Re: Proposed State Significant Development

Location: 30 Loftus Road, Yennora (Lot 8 DP1233715)

Proposal: Resource Recovery Facility

Subject:	Pre-Lodgement Meeting Advice
Proposal:	Operation of a Resource Recovery Facility to process up to 150,000 tonnes per annum of general solid waste (non-putrescible), consisting of construction and demolition waste and commercial and industrial waste – State Significant Development (SSD-9320662)
Application No:	PL2021/0003
Property:	30 Loftus Road YENNORA NSW 2161
Legal Description:	Lot 8 DP 1233715

SWALE CATCHMENT PLAN

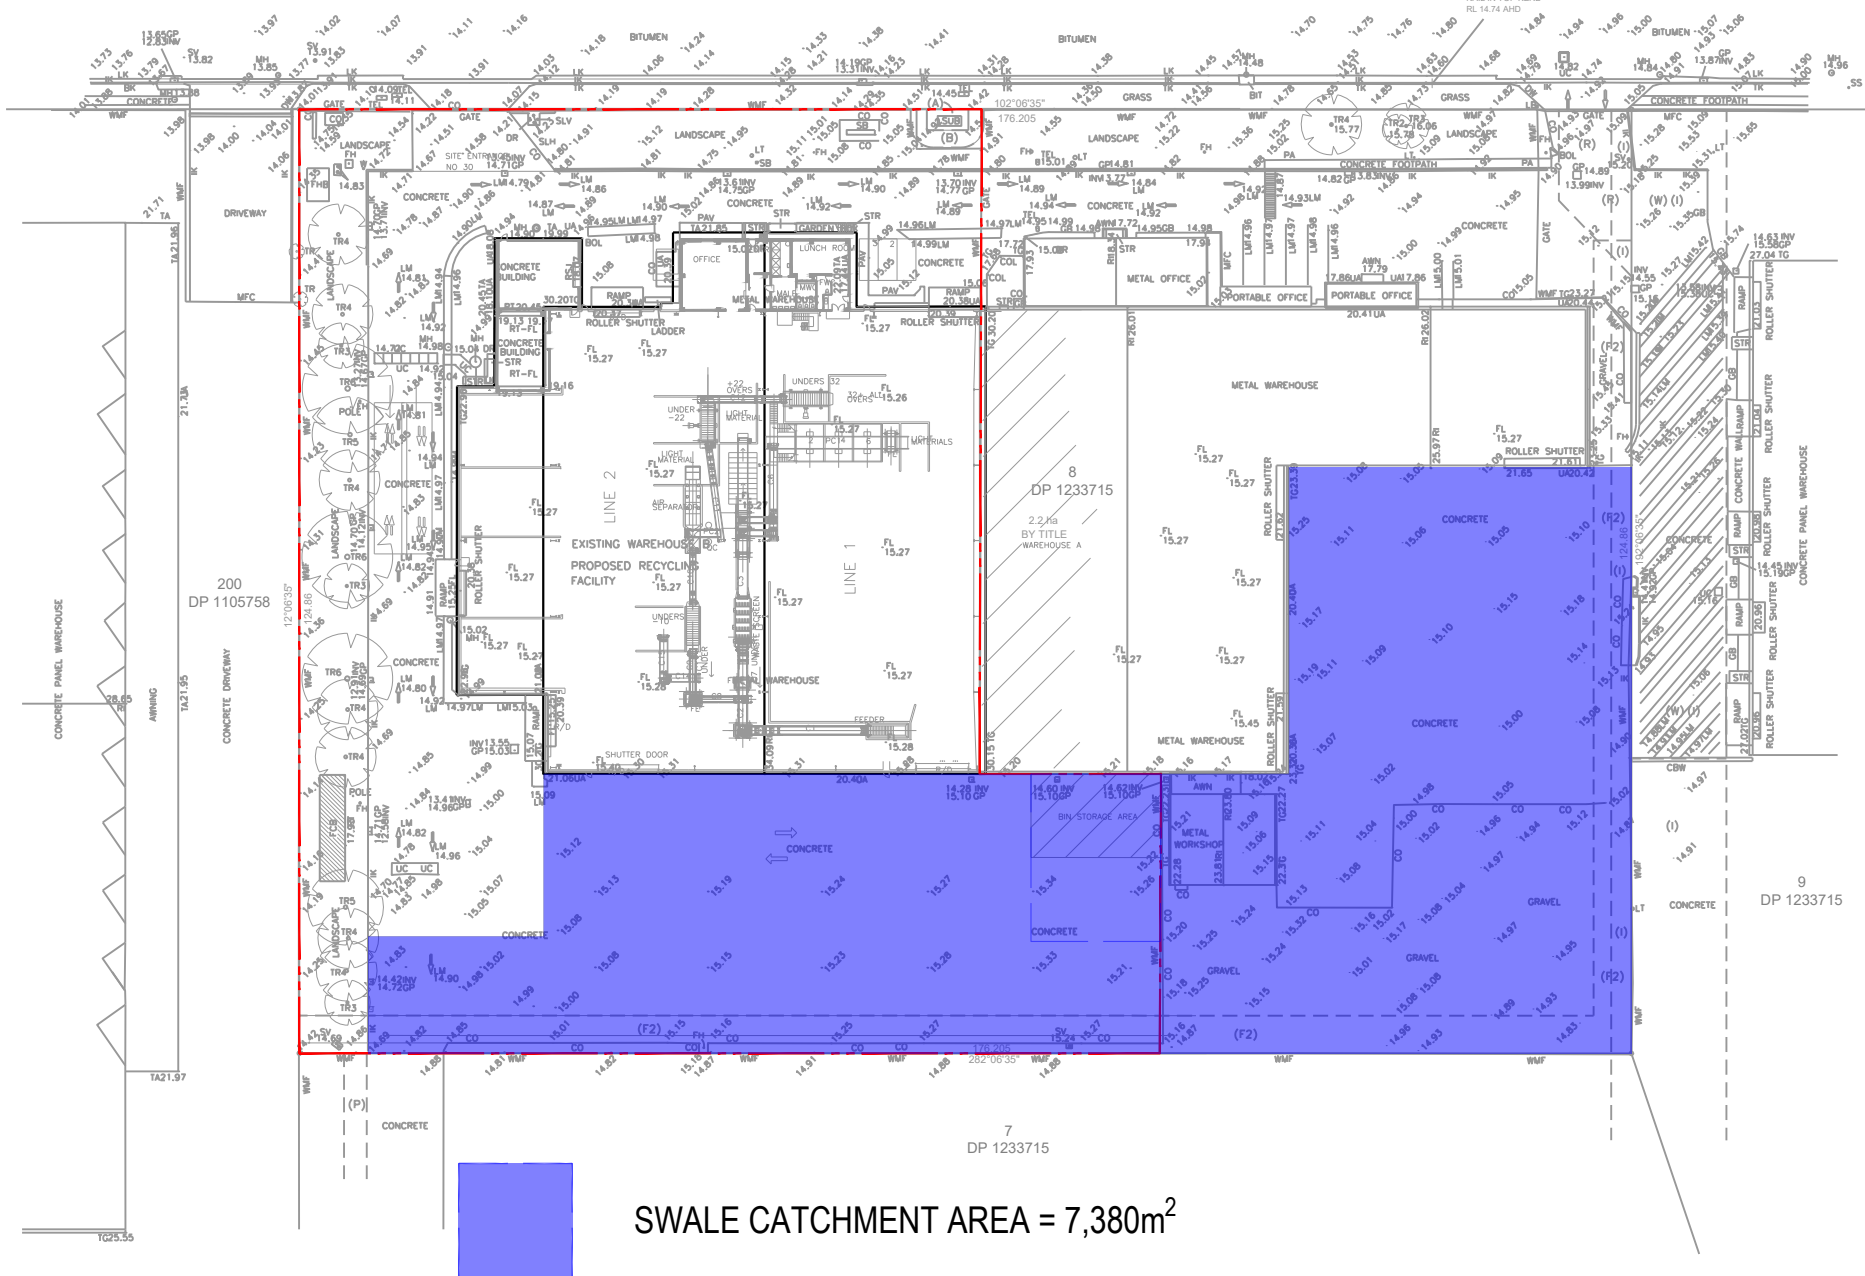
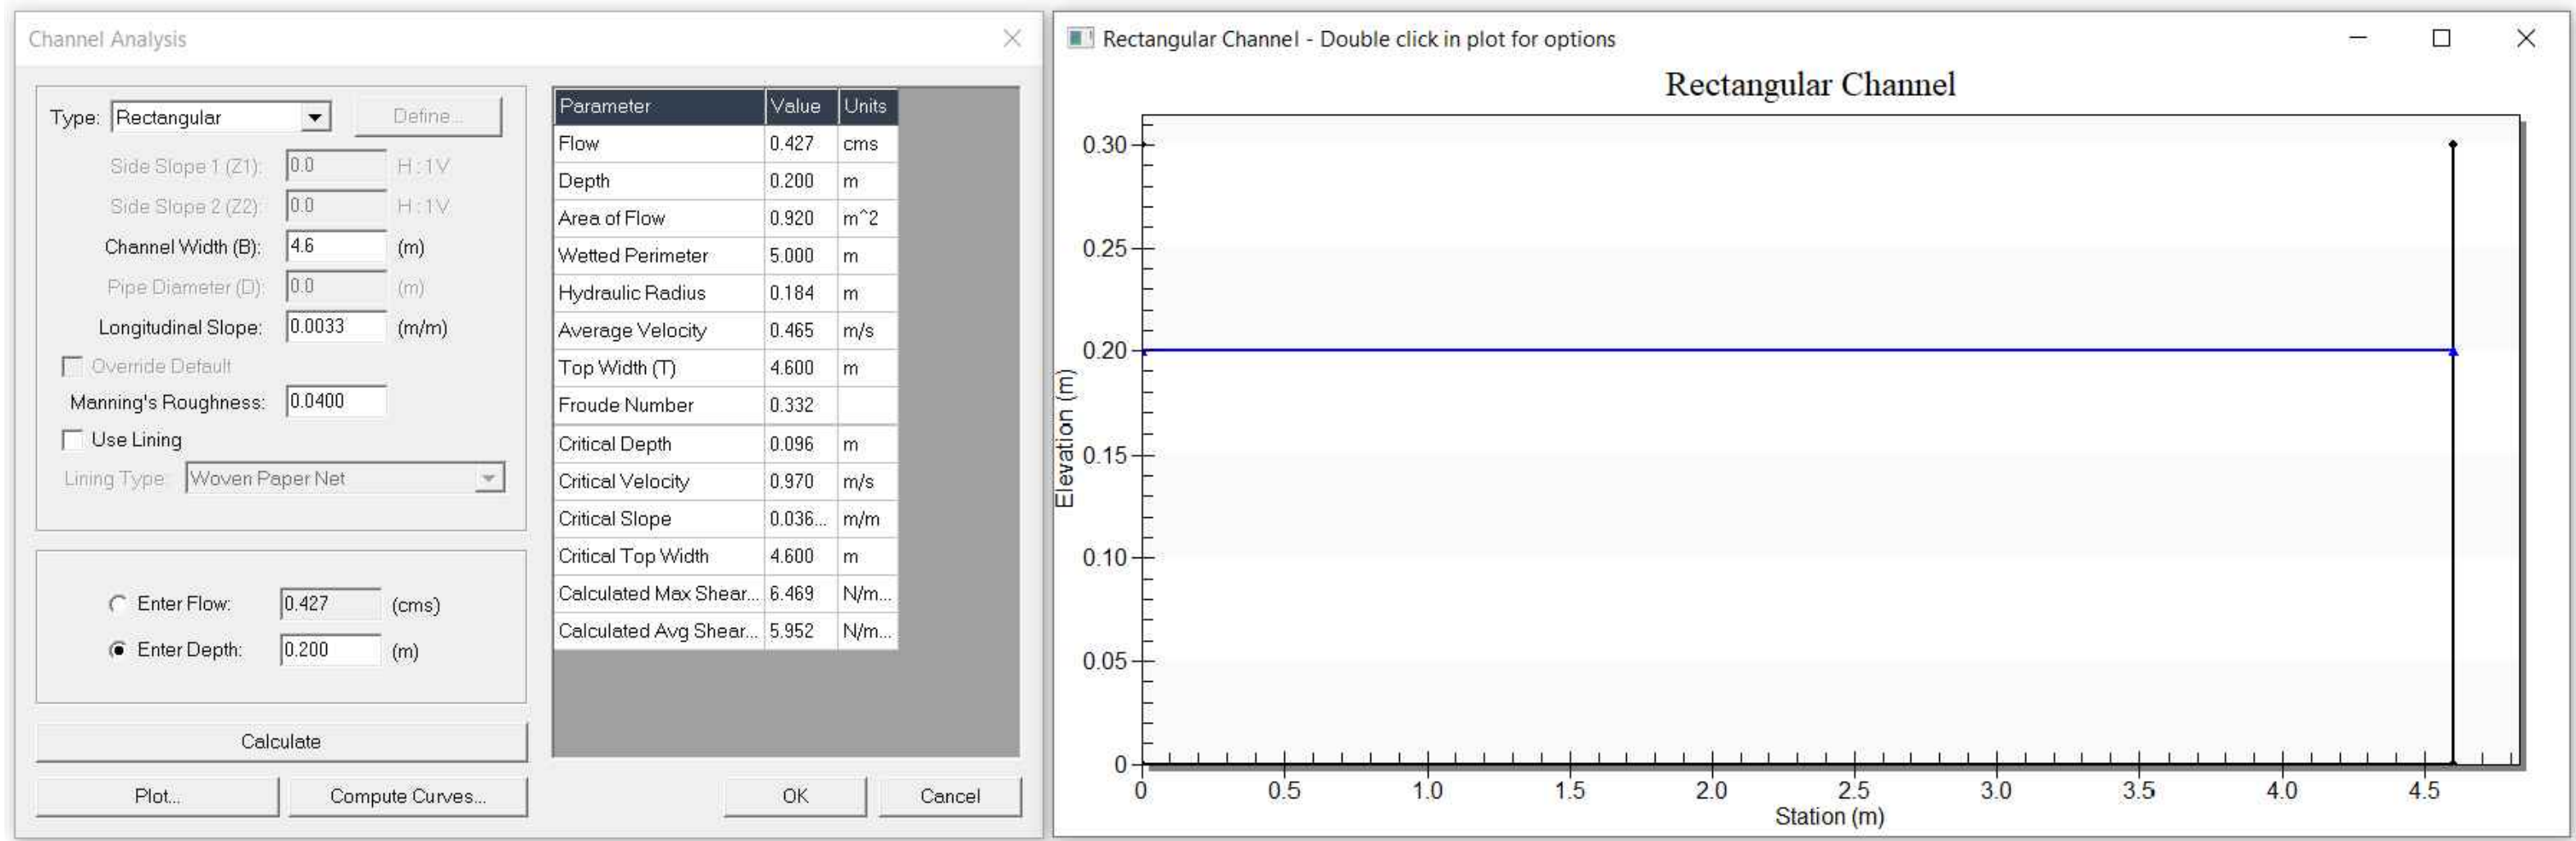
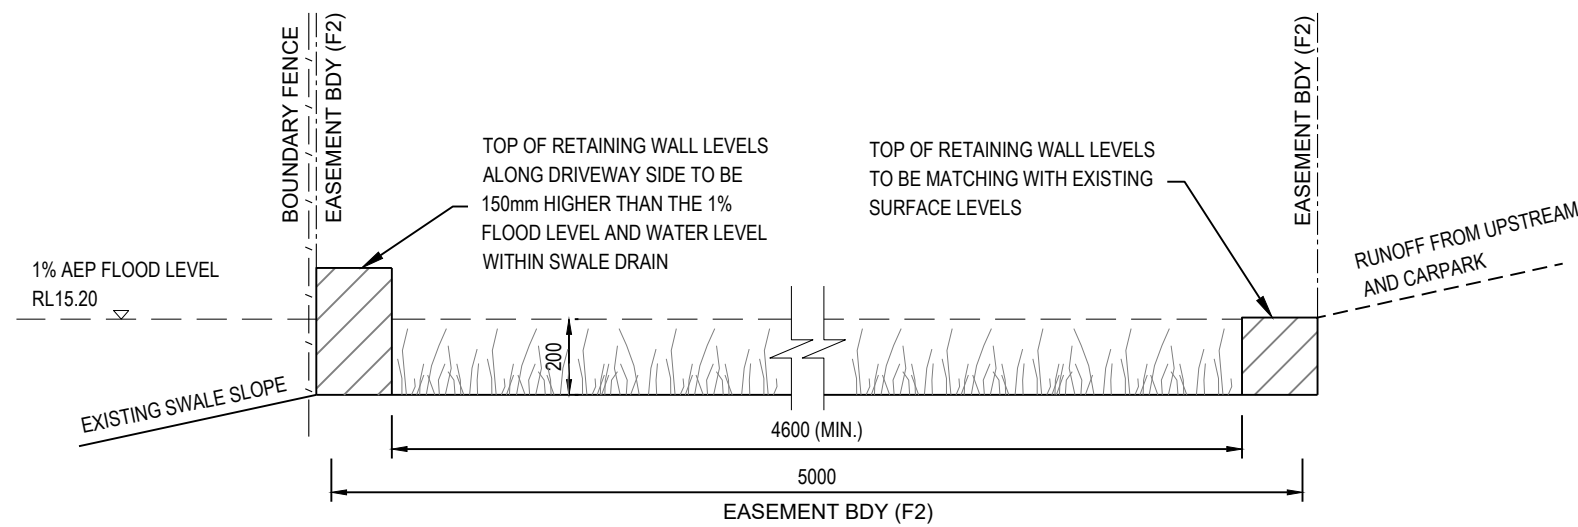
Further, the proposed car parking area on the southern side encroaches the drainage easement for food mitigation. Any alteration to the approved land conditions within the easement is not supported.

- d) The flood affected area including the flood storage area must not be obstructed that results in loss of flood storage volume or alters the flow characteristics such as change in velocity, depth, or redirection of flood.

Job No:
P630200
Dwg No:
C-4301

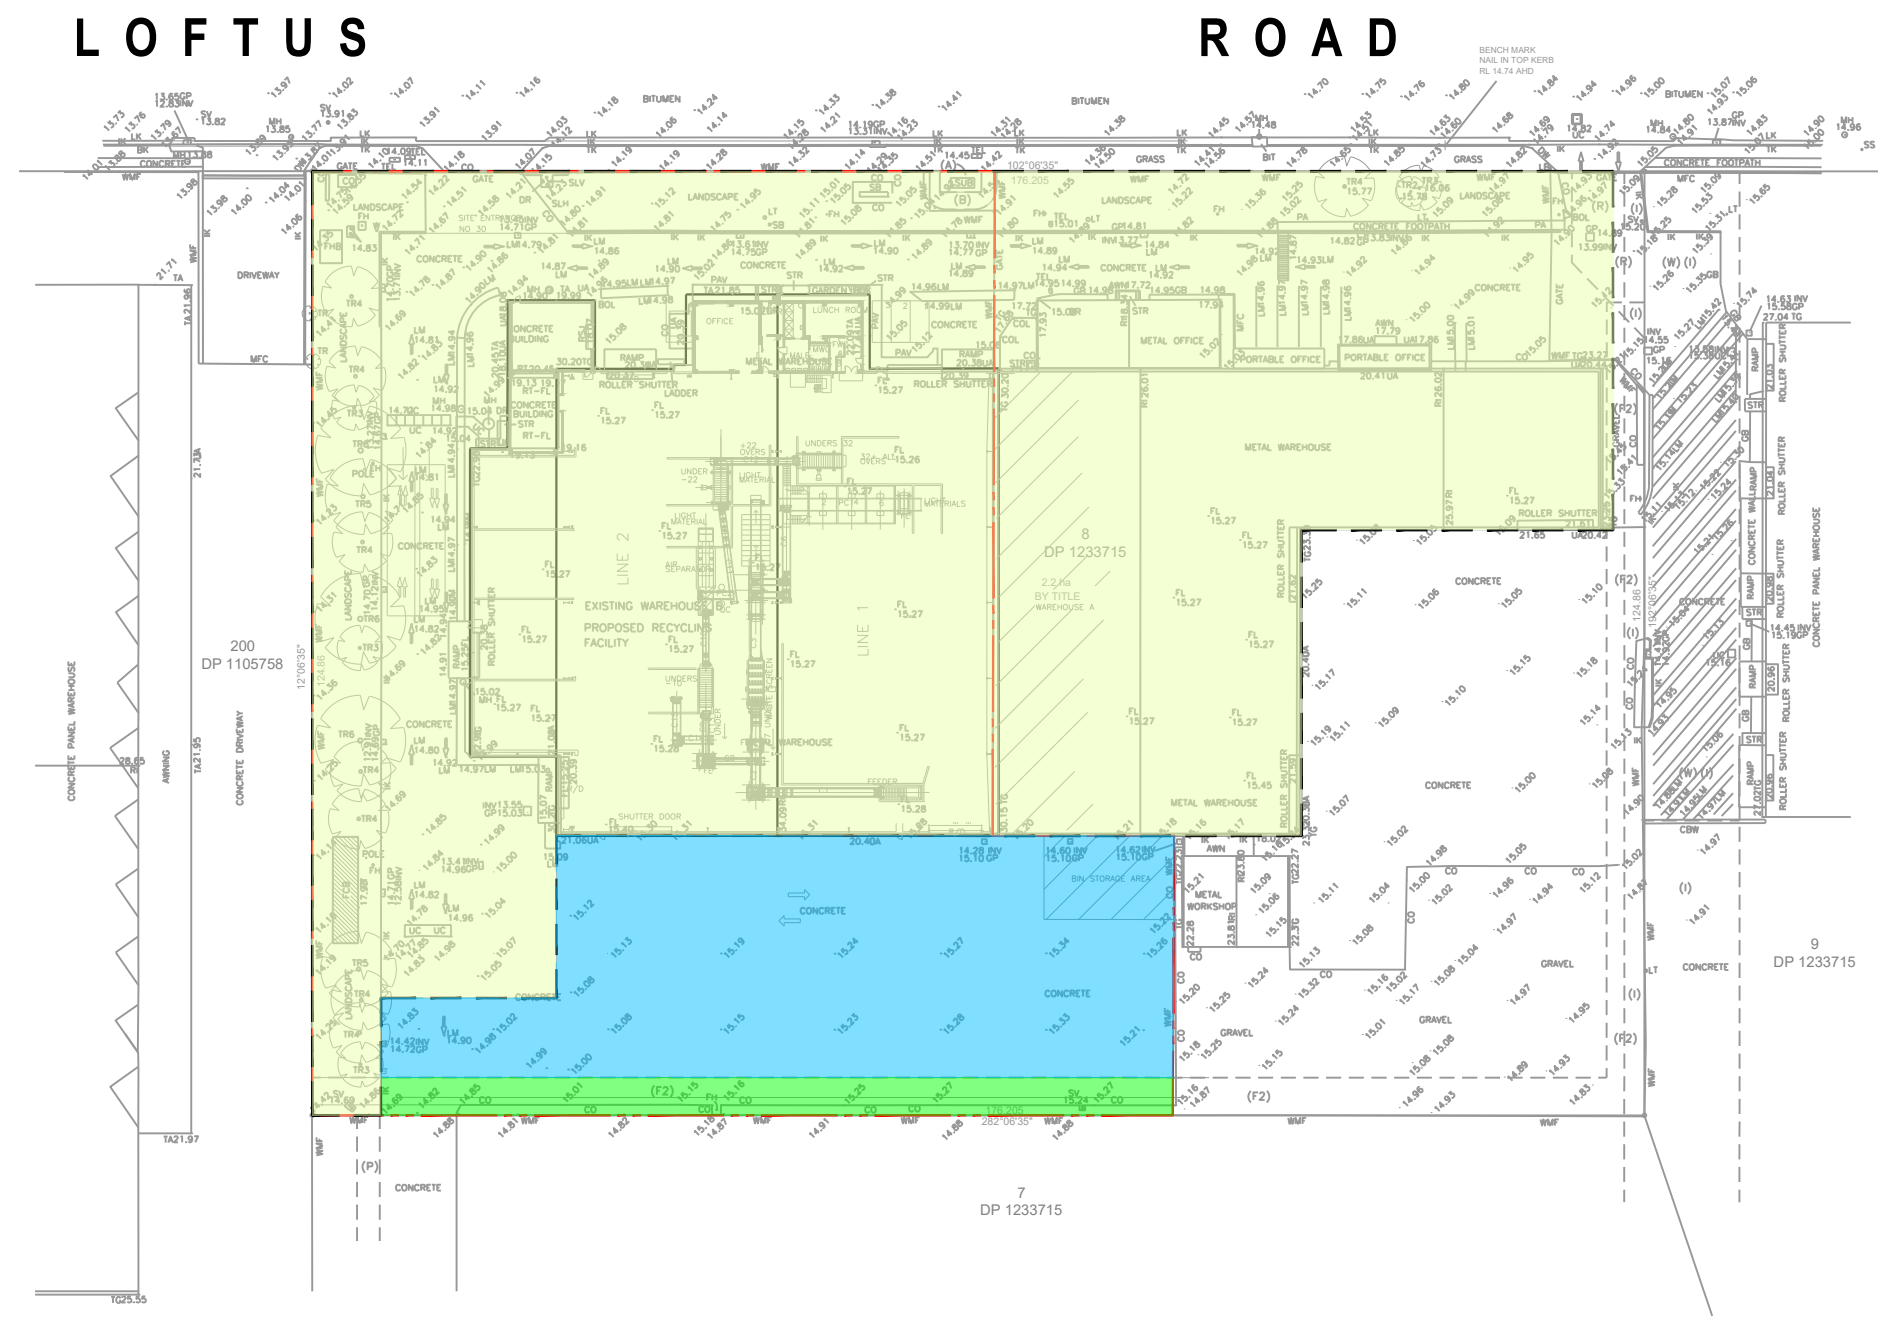
- e) Stormwater runoff (roof runoff) shall be reused and/or recycled to minimise the site runoff.
- f) In accordance with the section 7.5 of Holroyd DCP 2013 the development must incorporate the Water Sensitive Urban Design Measures to comply with the controls outlined therein and achieve the pollutant removal targets. The WSUD measure must accompany a MUSIC model.

Stormwater runoff from the area exposed to rain such as the manoeuvring area around the building including access ways must undergo appropriate industrial standard primary treatment / separation to achieve the pollution removal target prior to disposal into existing stormwater systems. The water quality treatment device must be capable of capturing and removing letters, sediments grits and hydrocarbons (oil/ grease). The area prone contaminated with hydrocarbon (oil and grease) must be segregated and the stormwater runoff from the area must be collected separately and treated for removal of hydrocarbon. The effluent must not be discharged into stormwater system. It rather be disposed into the sewer system with the approval of Sydney water.

- g) No stormwater plan detailing the management measure was submitted. The stormwater runoff from the site must be controlled by provision of On-Site Detention system as a part of site stormwater management measure. The on-site detention system must be designed with the OSD parameters of site storage requirement (SSR) of **300m³/ha** and the Permissible site discharge (PSD) of **140l/s/ha**.

Further, the On-site Detention storage must not cause the blockage or obstruction of flood/ through the site. The design needs to be accompanied with the OSD design calculation summary sheet and prepared by a qualified with an engineer's design certificate.
